WELWYN HATFIELD COUNCIL – DEVELOPMENT CONTROL
DELEGATED REPORT

APPLICATION No:	S6/2011/1567/LU
----------------------------	------------------------

The proposal seeks a certificate of lawfulness for the erection of a two storey rear extension measuring 3m in depth, a single storey rear extension beyond the existing garage measuring 3.6m in height and 8.5m in depth, a single storey side extension measuring 6.4m in width, 3.8m in height, 9.9m in depth and loft conversion.

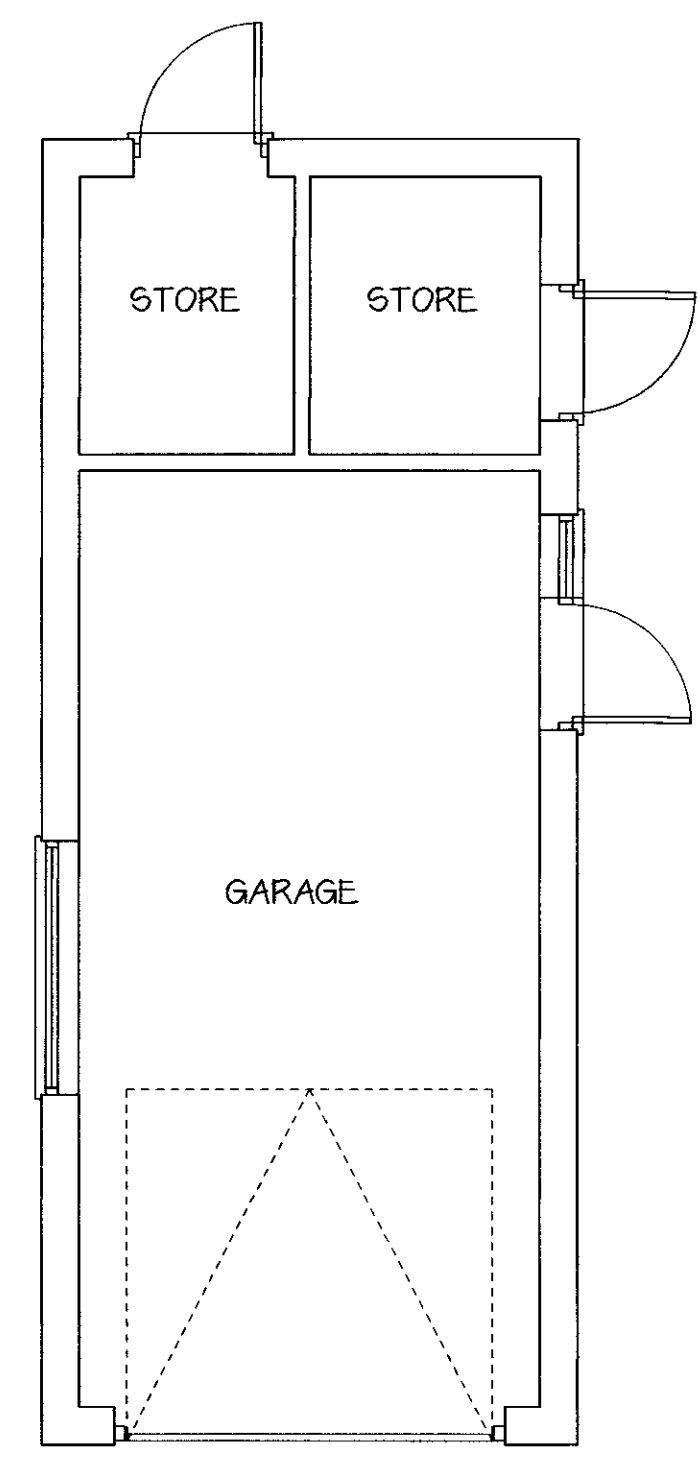
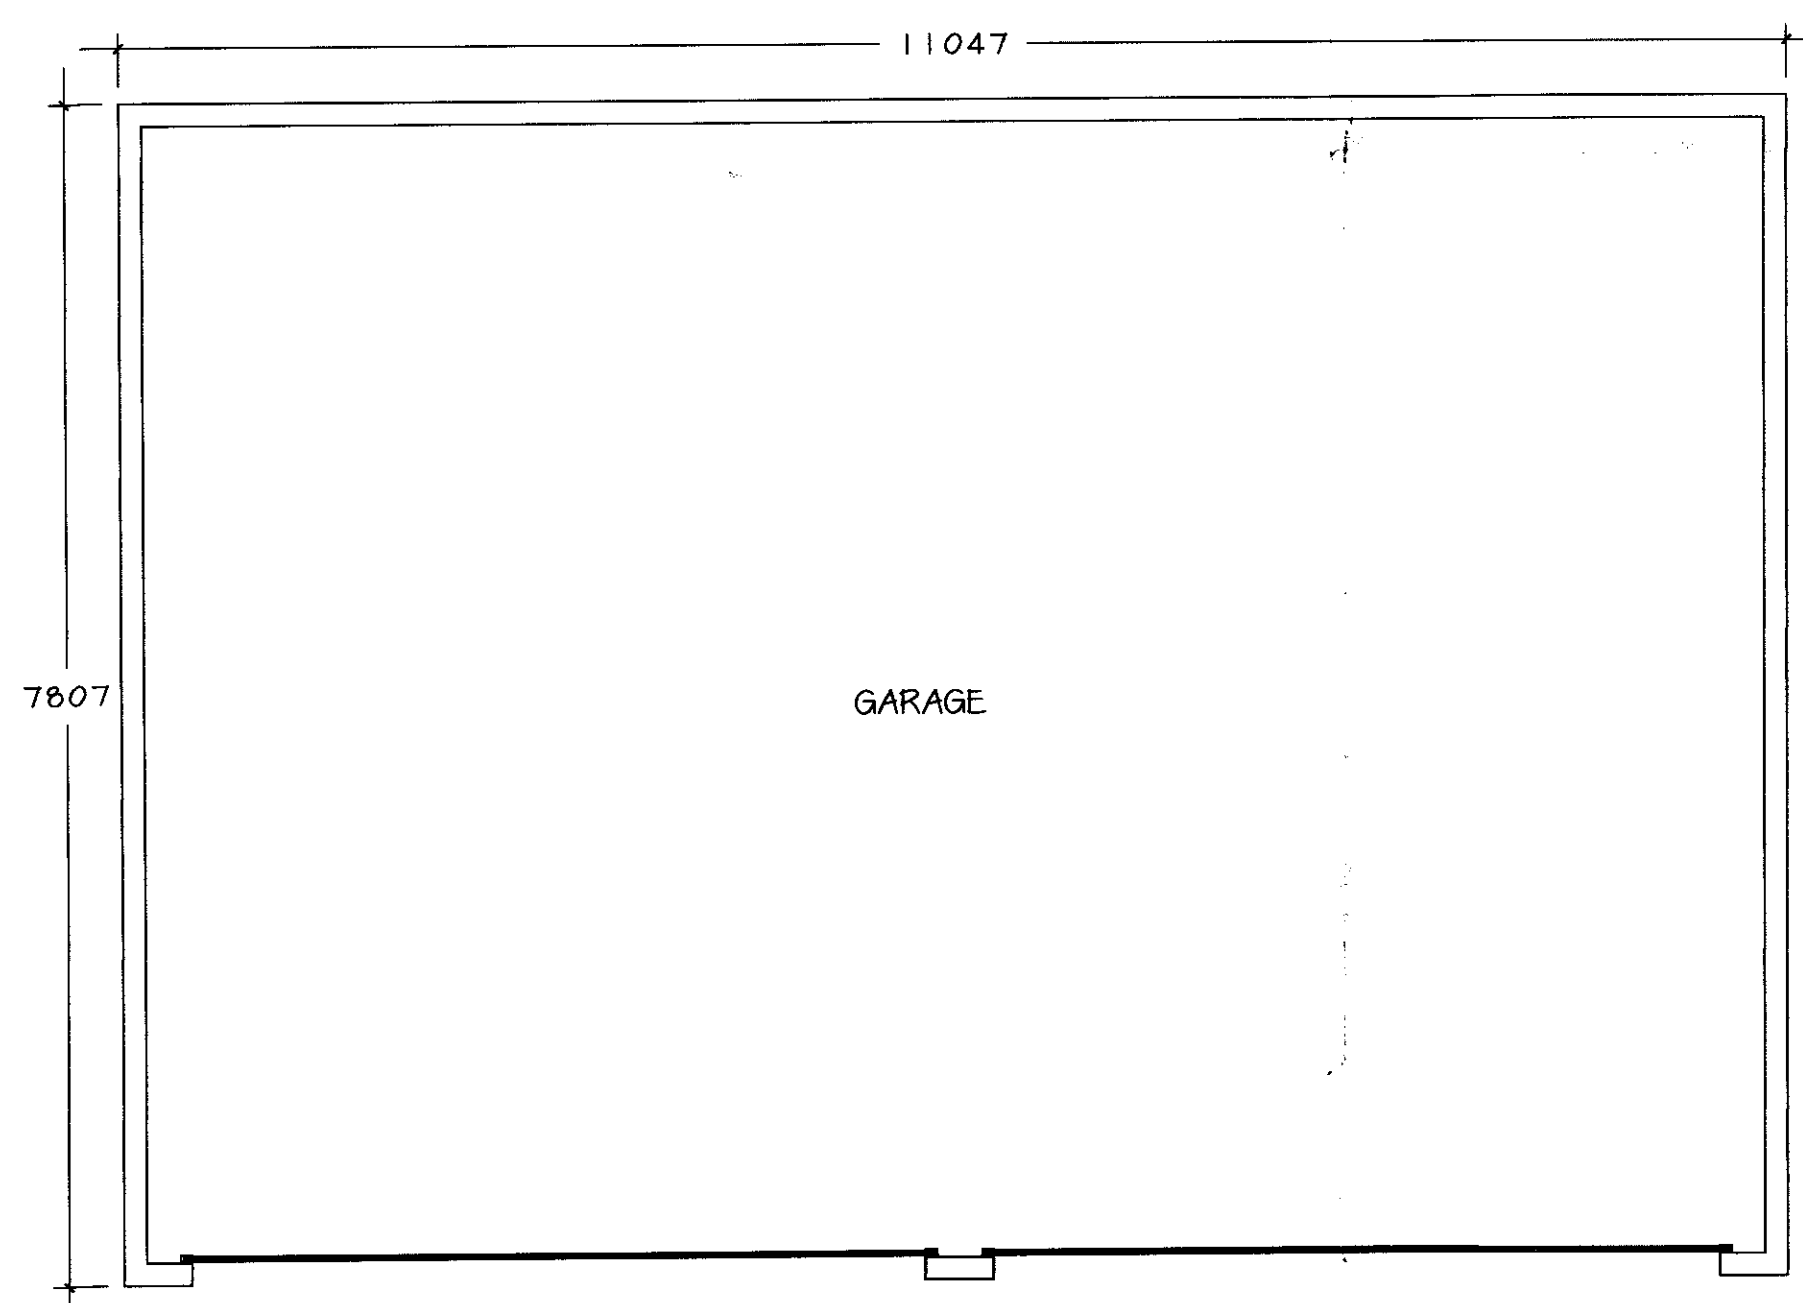
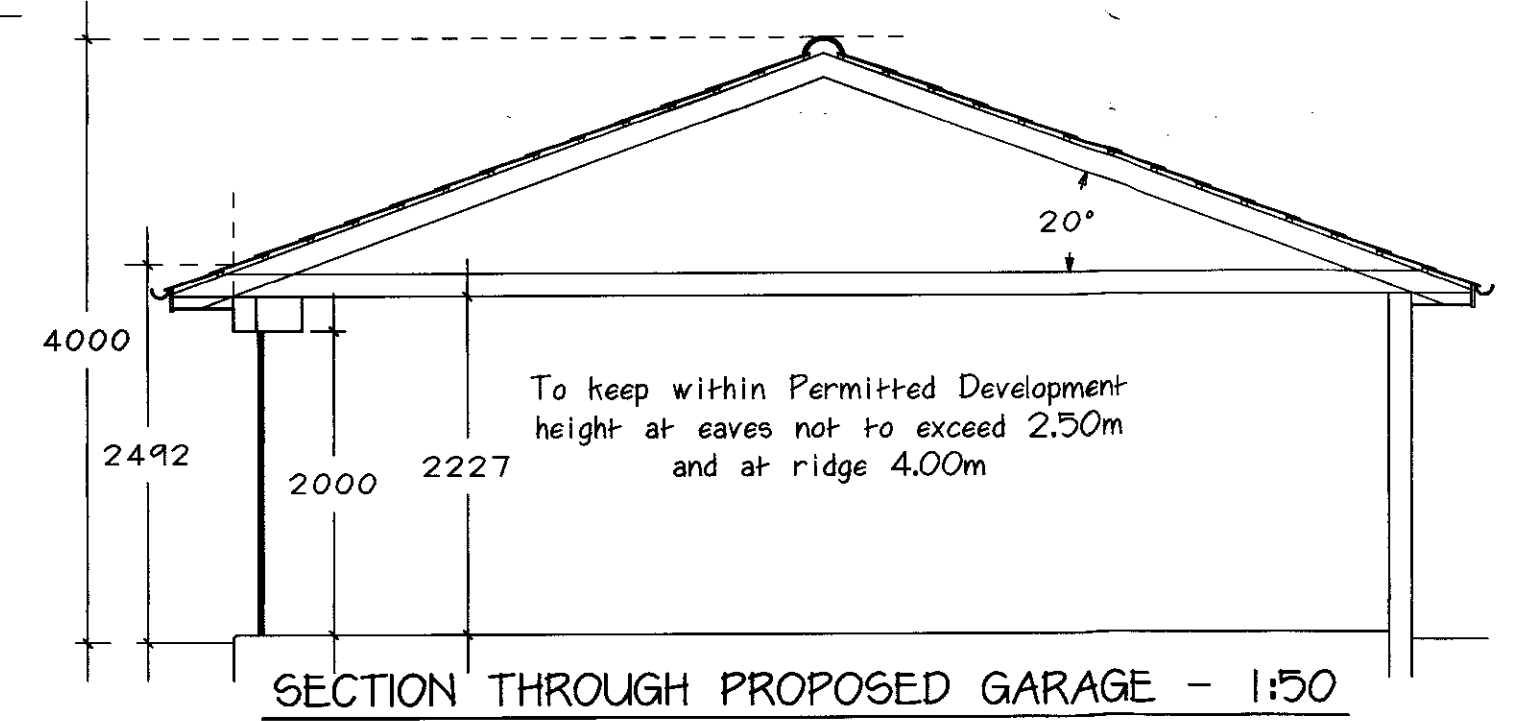
The proposed double garage has a dual pitched roof and measures no more than 4 metres in height

The height of the eaves of the proposed double garage would not exceed 2.5m

Along the south western extent of the parcel of land containing the dwellinghouse is fencing which further seeks to separate the parcels of land. Evidence has not been put before me which suggests that the parcel of land to the rear can be considered as part of the residential curtilage taking into consideration the above. Whilst the stables have ceased use, the two parcels of land in question remain defined by existing boundary treatments and it is considered that the parcel of land to the rear does not constitute part of the residential curtilage. Therefore, the proposed extension and conversion of the existing stable block to a double garage cannot be considered under permitted development.

PROJECT: Proposed extension, loft conversion & alterations DRAWING NUMBER: 11015/9

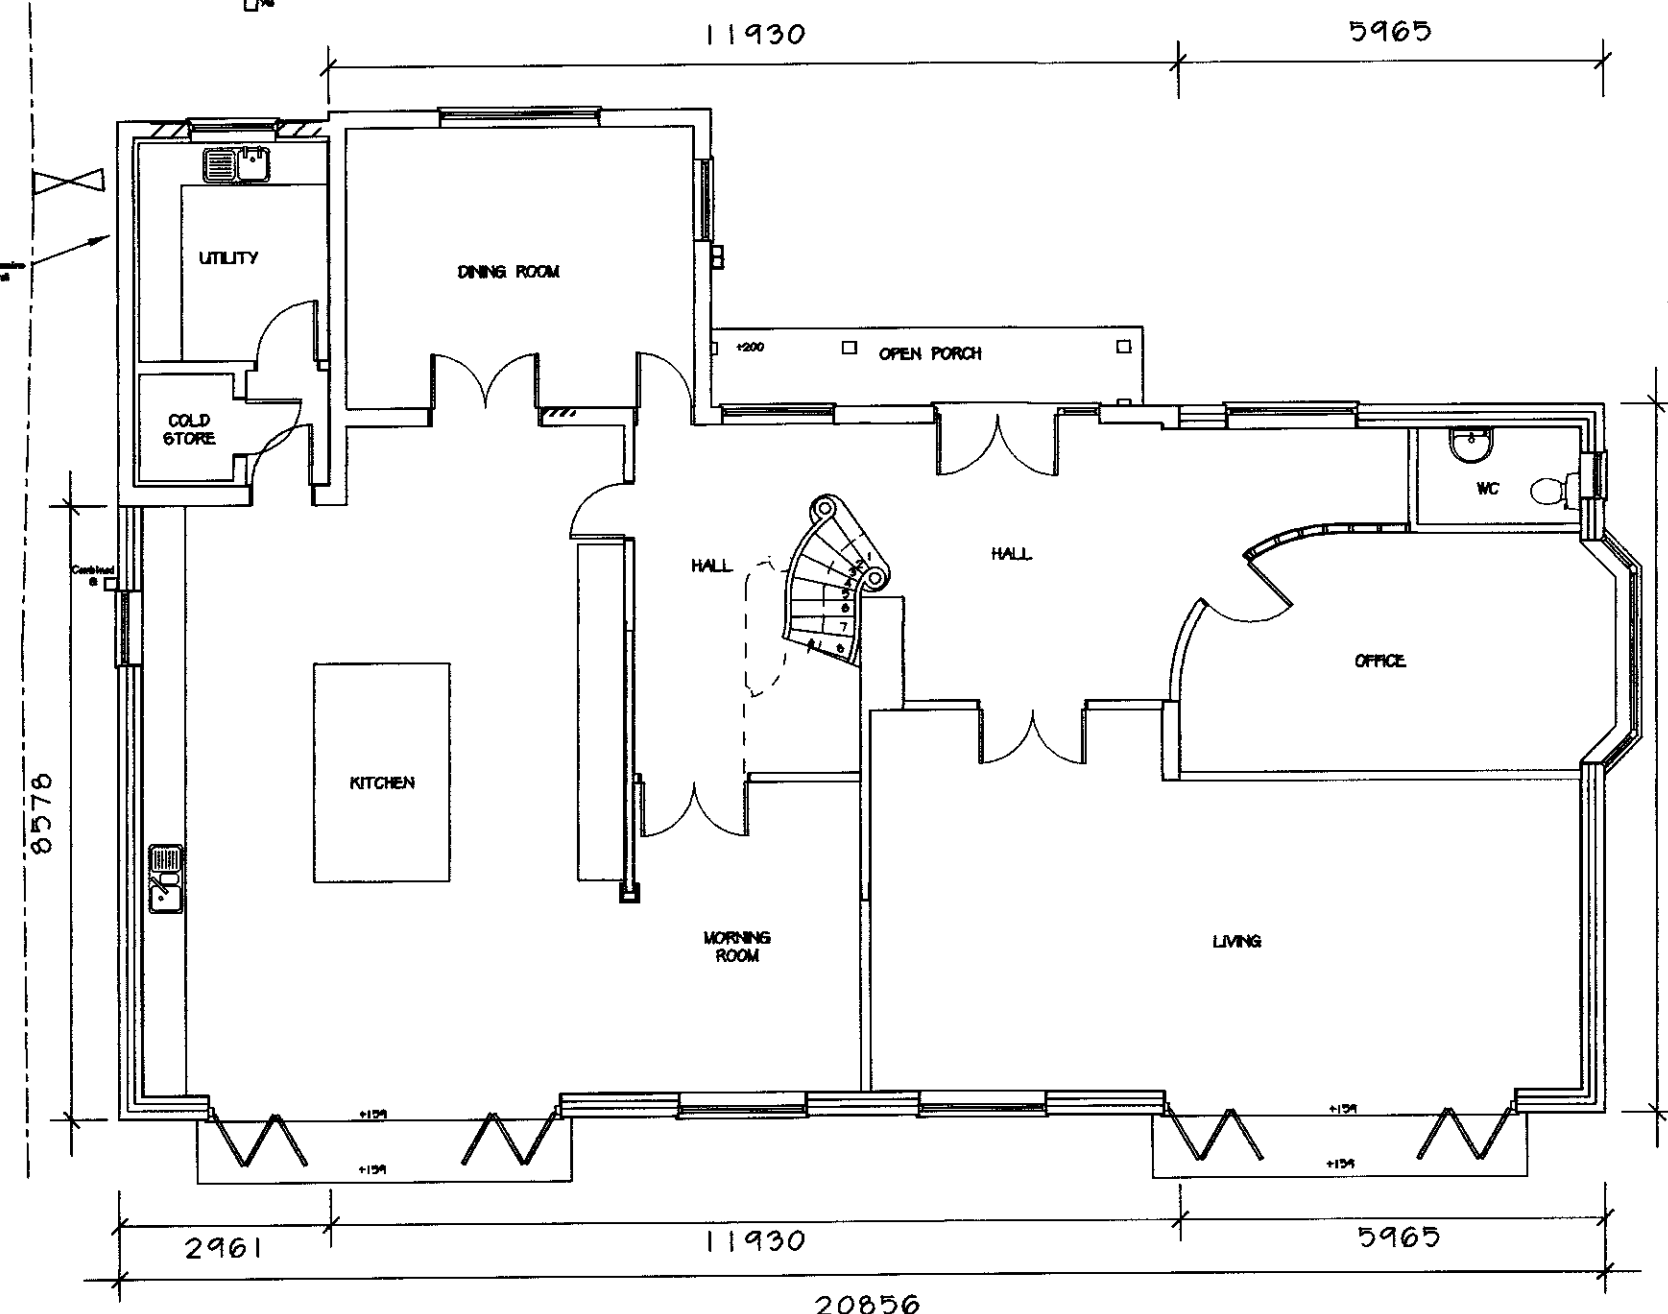
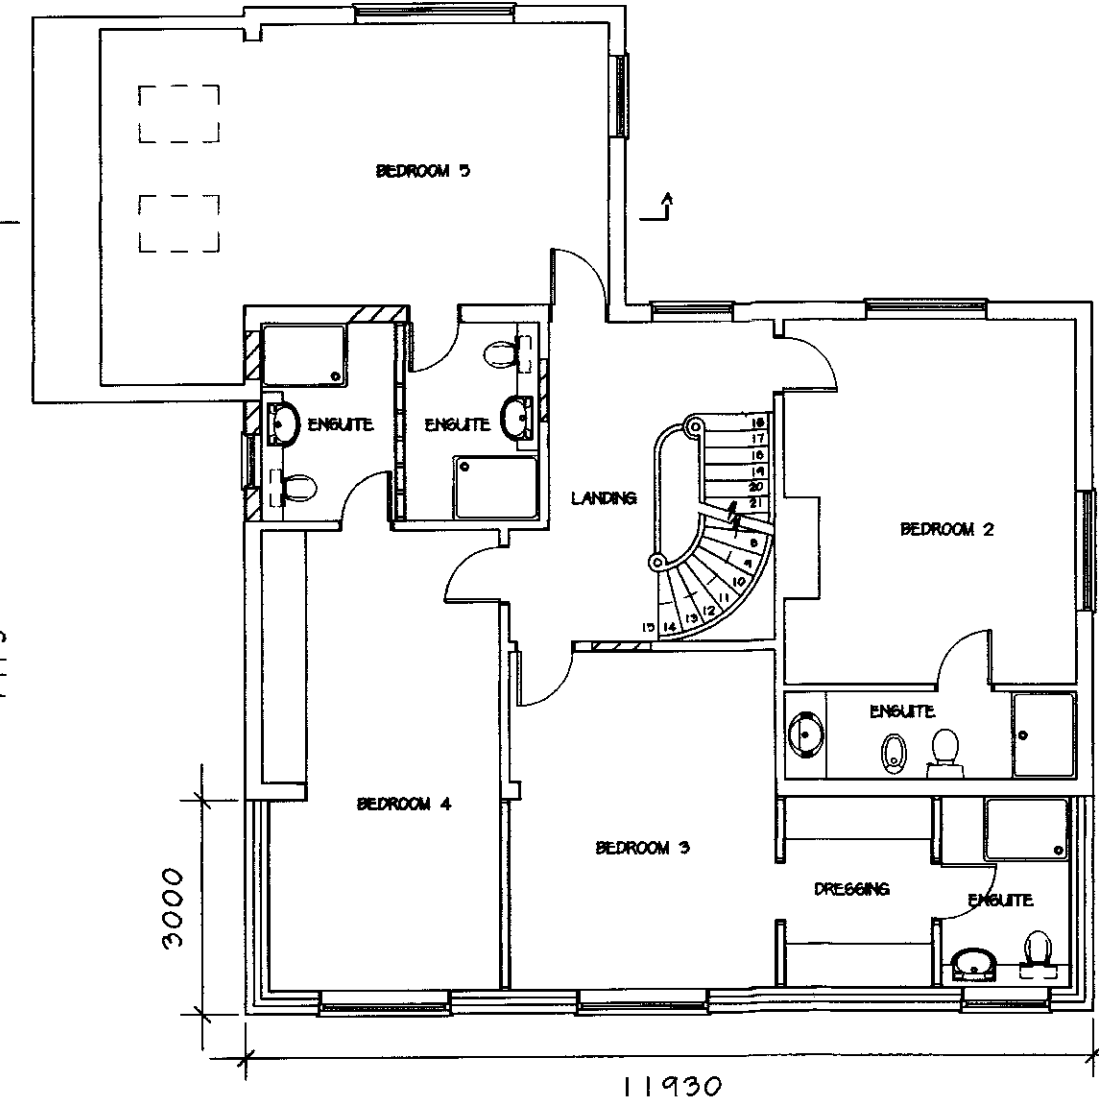
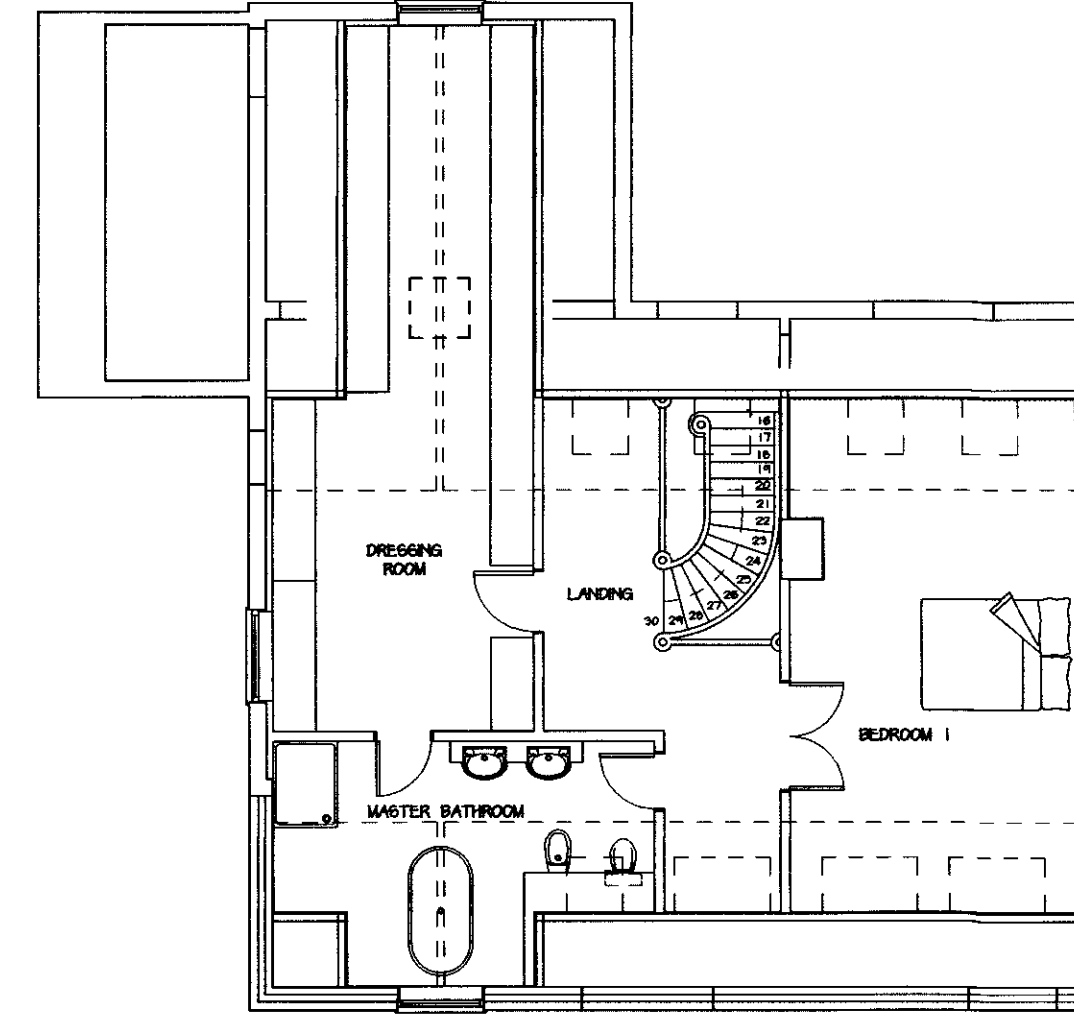
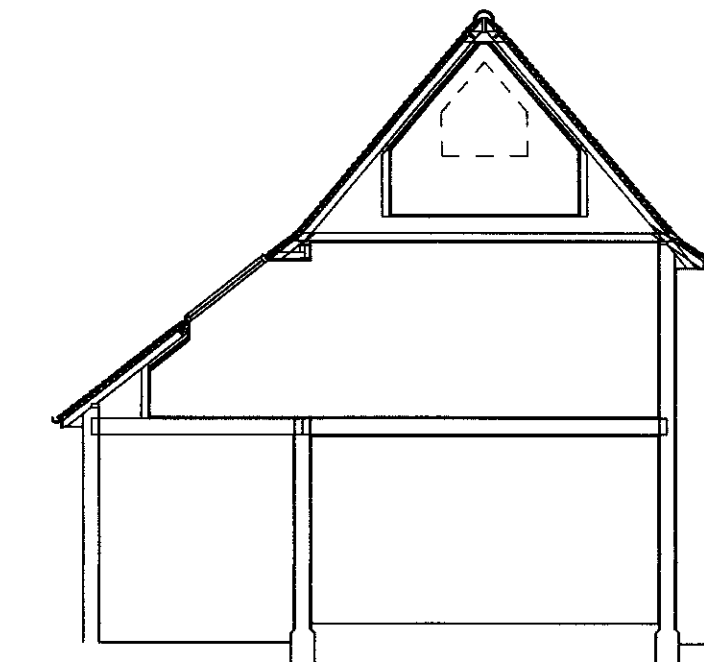
The existing utility room is to be demolished as part of the proposal and therefore the proposed extension on the north eastern side elevation measures 8.5m from the rear wall of the existing garage (original dwelling) which fails to comply with part (e) (i)

As part of the proposals, many of the internal walls are to be removed. However, for the purposes of this assessment, the proposed rear extension which would extend beyond the rear walls of the existing kitchen, WC, hallway and living room on the ground floor and bedroom 3, WC, bathroom and ensuite on first floor as shown on drawing 11015/2 would measure 3m in depth.

The single storey extension on the north eastern elevation measures within 2 metres of the boundary. However, the height of the eaves do not exceed 3 metres.

The proposed extension on the south western side elevation measures 6.5m from the side elevation of the existing dwellinghouse and would not exceed 4m in height.

However, the proposed side extension would have a width greater than half the width of the original dwellinghouse when considered in combination with the proposed rear extension which will effectively create a 'wrap around' extension. Page 26 of the Technical Guidance referenced above under part (e) shows examples where an extension fills the area between a side elevation and a rear wall. In this instance, part of the single storey side extension connects with the proposed two storey rear extension. The ground floor element of the rear extension when combined with the proposed side extension will extend more than half the width of the existing dwellinghouse.

The application drawings have not shown the windows proposed on the upper floor side elevation to be obscured glazed and non opening below 1.7 metres. However this is a condition attached and applicable to any approval and must be complied with in order to be lawful.

The applicant has not submitted roof volume calculations or roof plans as part of the proposal and therefore the calculations are approximate.

Rear elevation gable: 10m³

Side elevation gables: 18.8m³

Roofspace above two storey rear extension: 105m³

Roofspace above single storey side extension: 48m³

Roofspace above single storey rear extension: 28.6m³

Total additional roofspace: 210.4m³

The proposal therefore fails to comply with Class B (c) by virtue of the additional volume of the roofspace exceeding 50m³ upon the roofspace of the original dwelling

- Class A (e) (i) by virtue of the proposed extension on the north eastern side elevation measuring more than four metres from the rear wall of the existing garage (original dwelling),

- Class A (h) by virtue of the proposed side extension having a width greater than half the width of the original dwellinghouse when considered in combination with the proposed rear extension which will effectively create a 'wrap around' extension,

- Class B (c) by virtue of the additional volume of the roofspace exceeding 50m³ upon the roofspace of the original dwelling,
2. Evidence has not been put before me which suggests that the parcel of land to the rear which accommodates the stable block, as outlined in red on the Site Location Plan (1:1250), can be considered as part of the residential curtilage. Whilst the stables have appeared to cease use, the two parcels of land in question remain defined by existing boundary treatments and it is considered that the parcel of land to the rear does not constitute part of the residential curtilage. Therefore, the proposed extension and conversion of the existing stable block to a double garage cannot be considered under permitted development.
